Application for a non-material amendment following a grant of planning permission.

Replacement of extension and conservatory with single storey rear extension plus a loft conversion. New windows, doors, cladding and roofing to house. Boat house to be painted.

Reference number:	AW/212/19/HH
Date of decision	16/09/2019

CLIENT	Sara Adams & Chris Hodgkinson
PROJECT	5 Bay Walk
DRAWING TITLE	Proposed Elevations Sheet 02

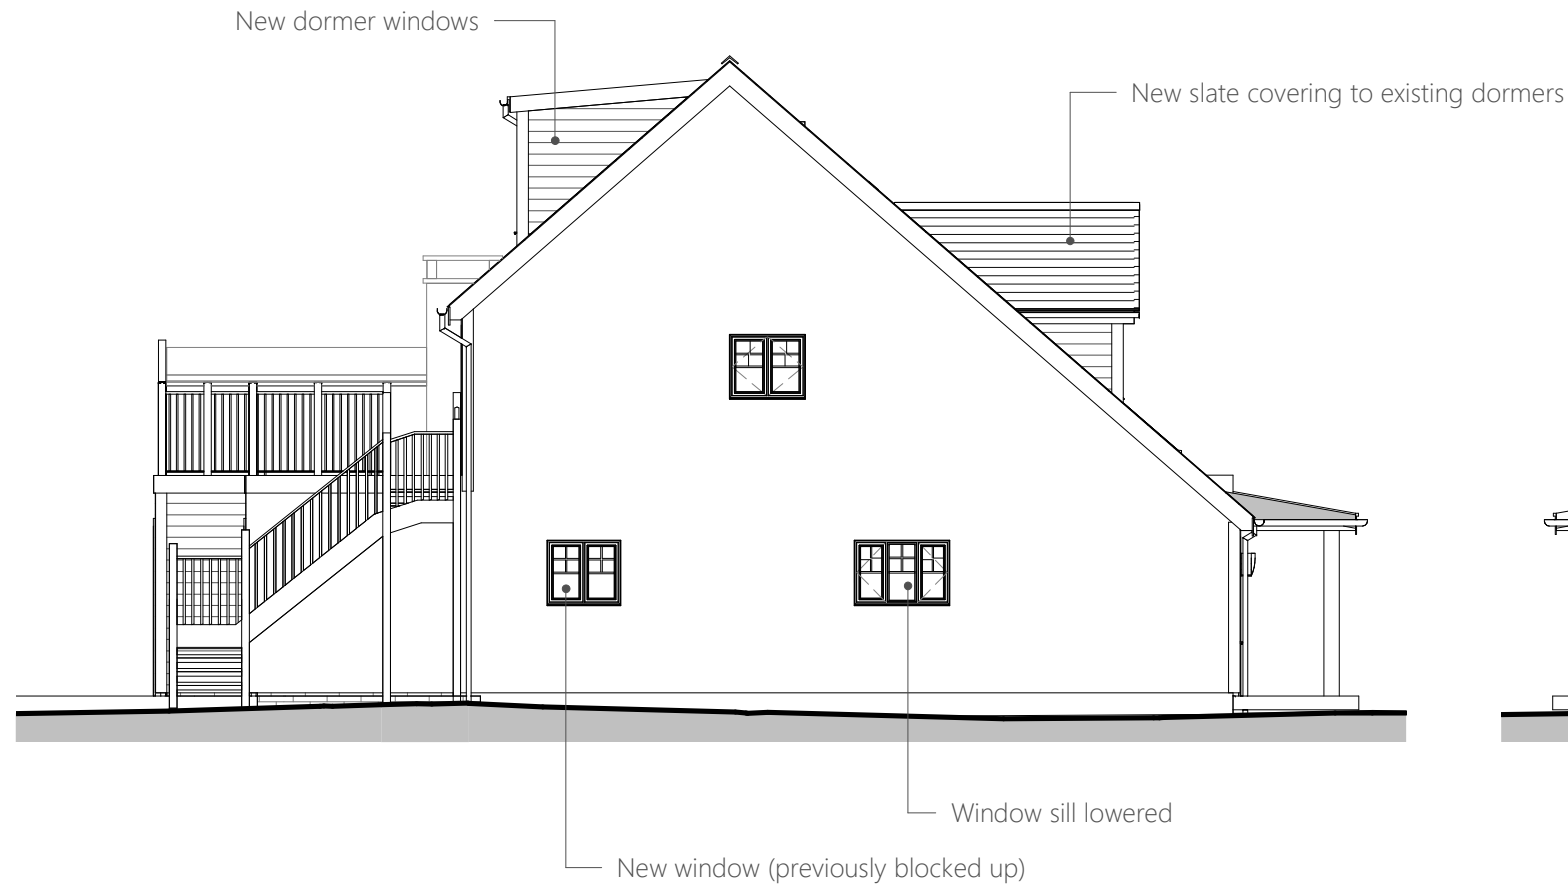
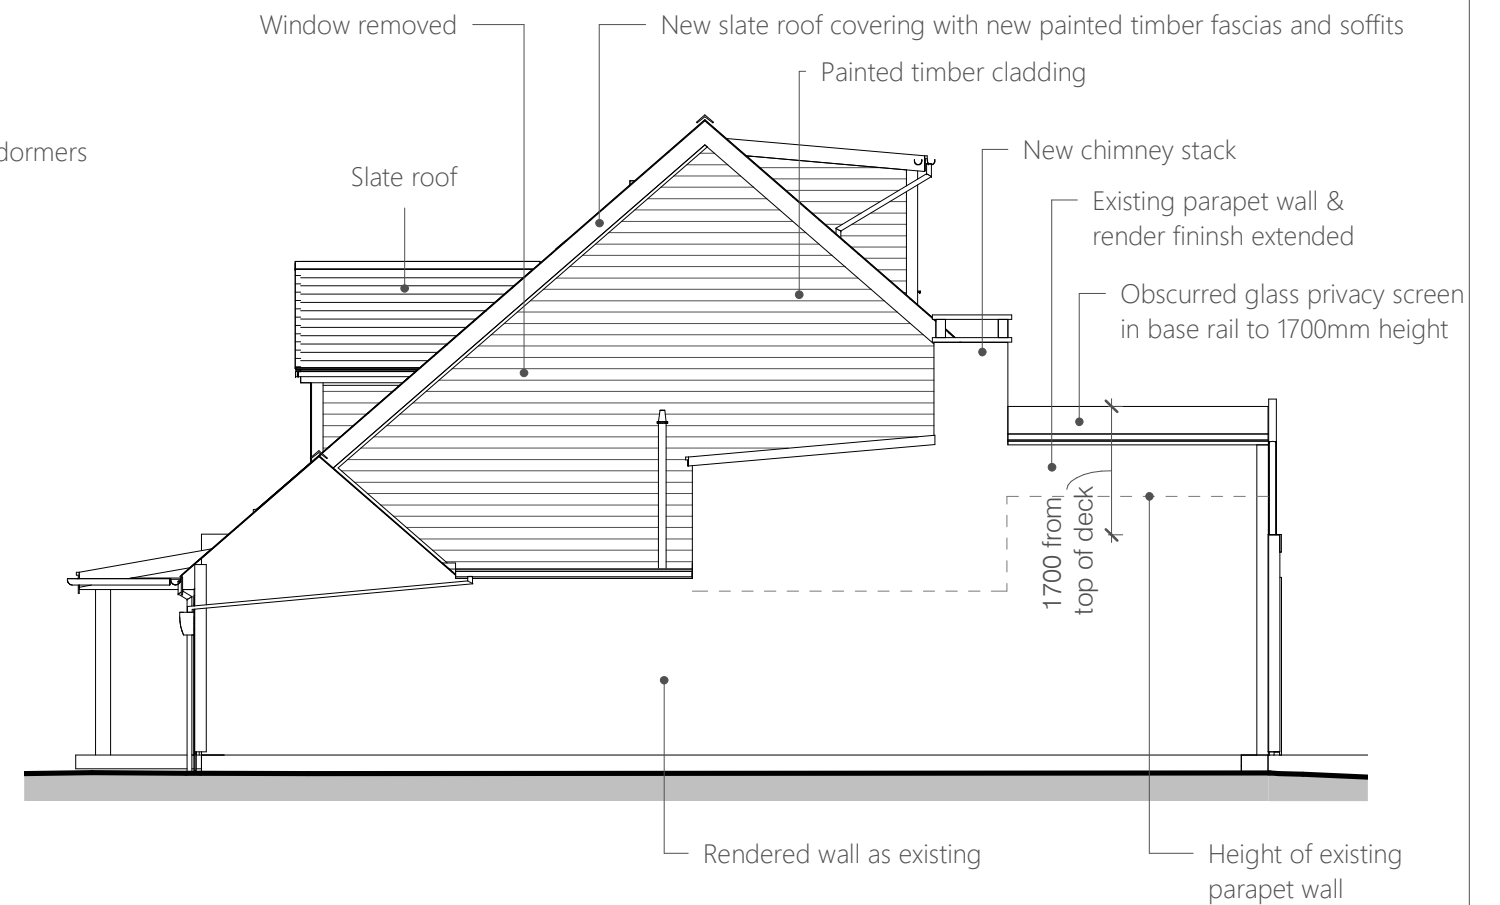
Re-positioning and enlarging one rear dormer window. Replacing window and french doors with wider french doors to rear at 1st floor. Western balcony to be masonry with glass privacy screen above to overall height of 1.7m

Window alterations are proposed to improve the usability of the loft conversion. The amendment to the western balcony is designed to provide 1.7m high privacy screening but avoid health & safety risks associated with constructing and maintaining a large pane of glass on a roof edge with limited access.

Proposed Elevations Sheet 01 - 179/3.201 Rev 08
Proposed Elevations Sheet 02 - 179/3.202 Rev 06
Proposed Roof and Site Plan - 179/3.104 Rev 05
